**KIRKLEES METROPOLITAN COUNCIL
INVESTMENT & REGENERATION SERVICE**

DELEGATED DECISION TO DETERMINE PLANNING APPLICATIONS

Reference No:	2022/62/90156/W
Site Address:	20, Marcus Way, Mount, Huddersfield, HD3 3YA
Description:	Erection of single storey rear extension and garage conversion with external alterations
Recommending Officer:	Laura Yeadon

DECISION – CONDITIONAL FULL PERMISSION

Title: Proposed Plans
 #

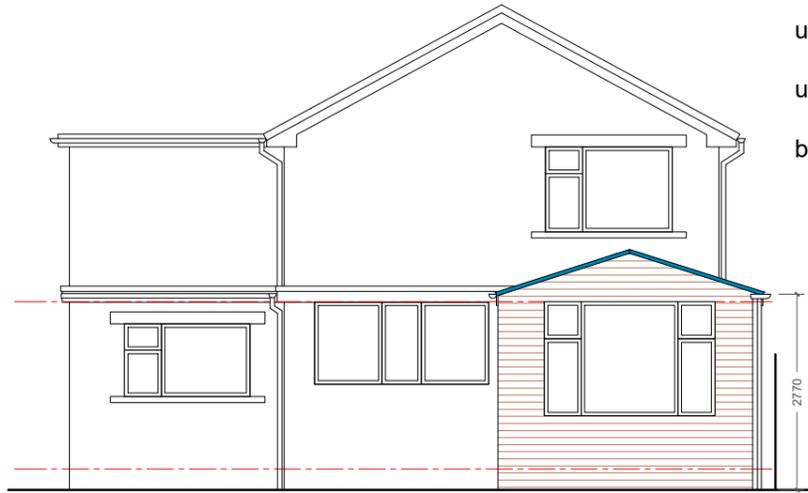
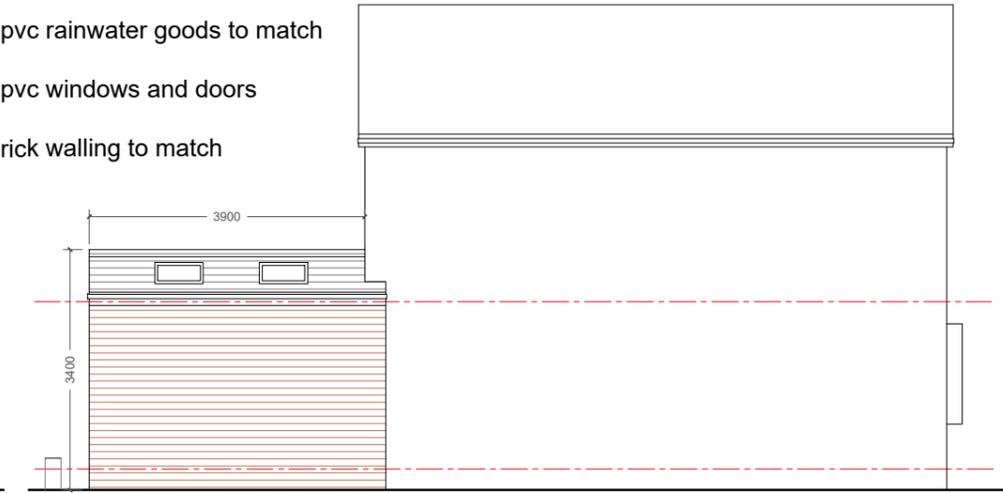
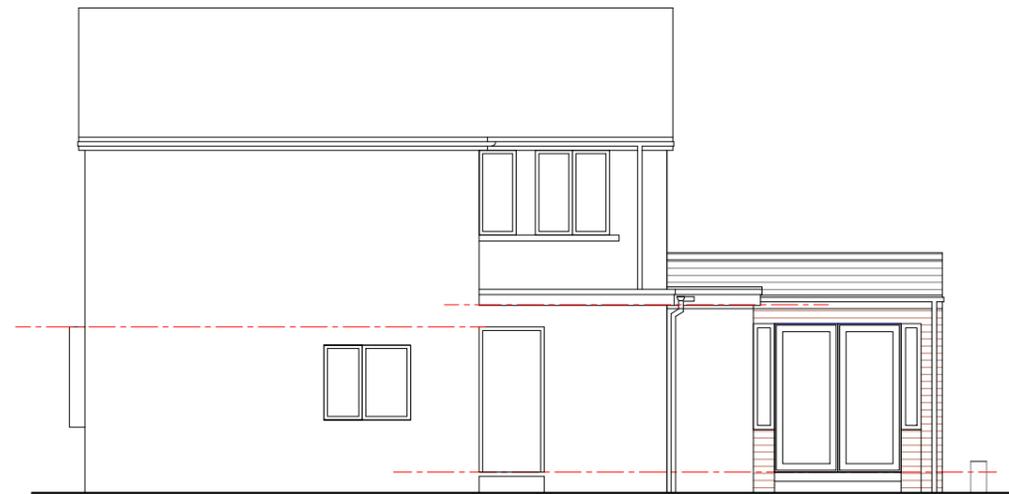
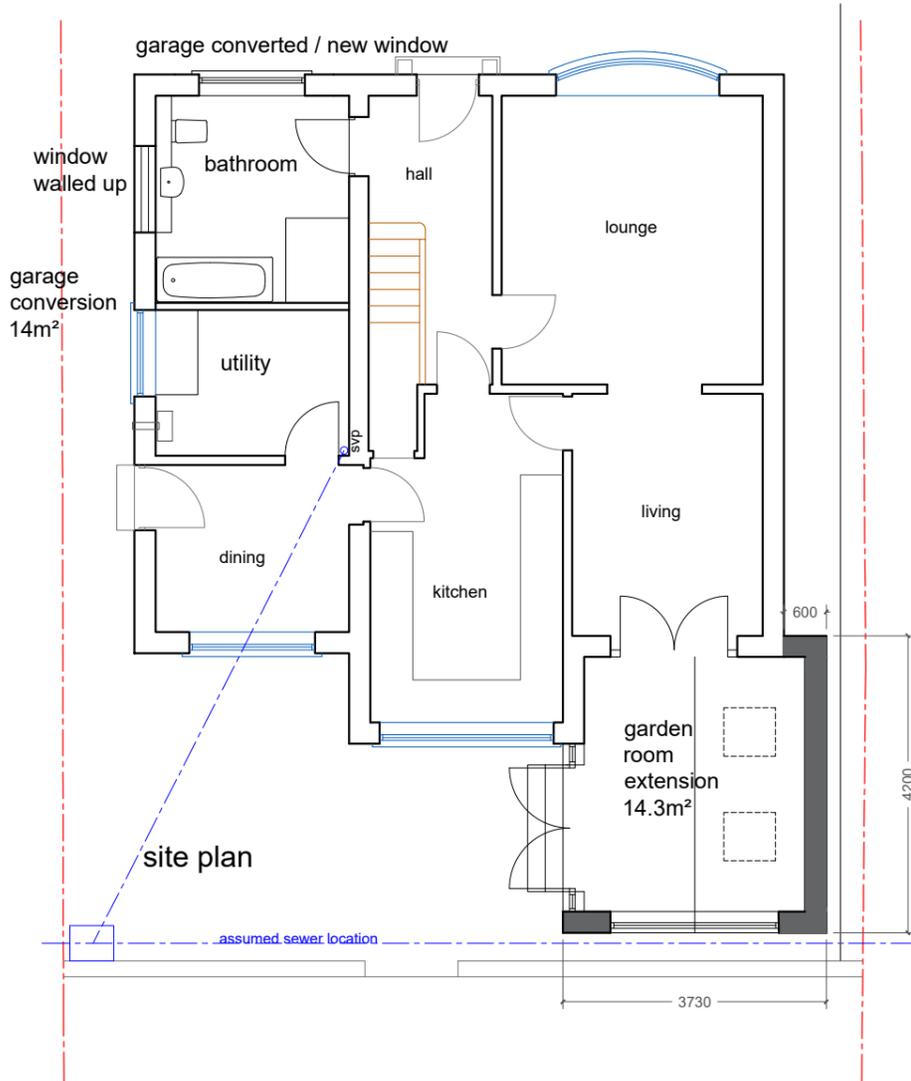
The proposed single storey extension would be located on the rear elevation of the property. The extension would project beyond the side elevation by 0.6 metres and would project 4.2 metres from the rear elevation. The proposed eaves height of the extension would be 2.7 metres with the overall height being 3.4 metres to the ridge. The proposed construction materials would be brick for the walls and tiles for the roof with uPVC for the windows and doors.

The design of the extension is such it would be to the rear of the property and therefore would not be visible within the street scene from public vantage points. The extension would be single storey in height and would therefore be subservient when read against the back drop of the two storey dwelling. The extension would accord with the SPD by virtue of being in keeping with the scale and style of the property by having matching materials and having a

pitched roof and would not exceed 4 metres in height. The extension would project slightly further than the 4 metres advised and would not retain a 1 metre gap between the boundary. Notwithstanding this, external access to the rear of the property is achieved as the other side of the property provides this access.

With regards to the rear extension, openings are proposed within the rear elevation and also the side elevation facing across the rear of the property. There are no openings with the side elevation facing directly towards No. 22 other than roof lights which are considered to be acceptable as due to their height would not lead to overlooking. The openings within the other side and rear elevations are considered to be acceptable given their orientation and distance from neighbouring properties.

With regards to overshadowing and/or being overbearing, the extension would face the side elevation of No. 22 and would be separated from this property by the driveway to No. 22 with this property set on a higher ground level. The

extension would project slightly more than the 4 metres recommended within the SPD however given the site layout, difference in levels and the extension being single storey in height, it is not considered that the proposal would have an undue impact from overshadowing or by being overbearing.

The proposed garage conversion would result in the existing garage door being removed and the openings walled up with brick to match the host property and a window inserted. The opening would align with the existing first floor opening which is considered to be acceptable.

With regards to the proposed garage conversion, the non-habitable garage accommodation would be altered to be a bathroom and utility room which are also non-habitable. The new opening would not decrease the existing separation distance between the front elevation and the facing properties and therefore this is considered to be acceptable.

As part of the development, it is proposed that the existing garage would be converted to provide accommodation. The internal measurements of the existing garage are 2.8 metres x 5.2 metres which falls short of the minimum requirements within the Highways Design Guide SPD. As such, there would be no loss of parking as a result of the conversion. 2 no. vehicles can park at the front of the property, as noted on the site visit and therefore it is considered that there are minimal concerns with regard to parking or highway safety.
